Your Ref: OWPC14225
Our Ref: WA/32/17/HH 02-05-2017
Please ask for:
Mr D Easton

Demolition of existing garage & shed & erection of single storey rear & two storey side extensions.

Pound Cottage The Street Walberton

PROPOSED SIDE ELEVATION
(EAST)
TAKEN THROUGH NEIGHBOURS' PROPERTY

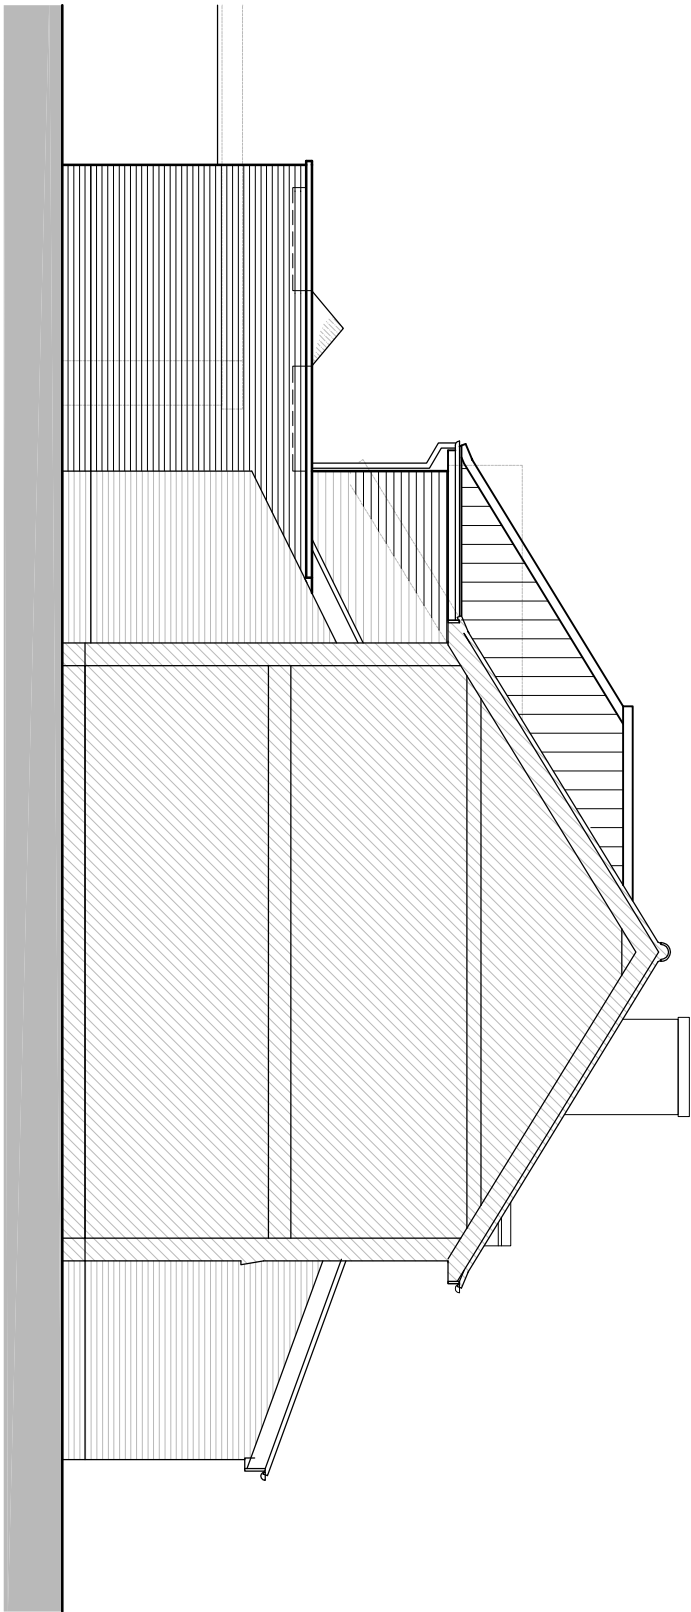
As the people most affected - we own and live in the house attached to Pound Cottage - we object to this planning application. The proposal would have a significant detrimental effect on our enjoyment of our property. It would result in further loss of light (and overshadowing) to our kitchen, dining area and small rear garden (which measures 6m x 6m) and, in our view, constitutes an over development of the site.

We do recognise that the applicants desire more living space and we have no major objection to the proposal to build on the side of Pound Cottage. However, we think the proposal to further extend at the rear is a development too far. It is out-of-scale and, as stated, will have a serious, negative impact on our enjoyment of our own home. We request that the application be rejected.
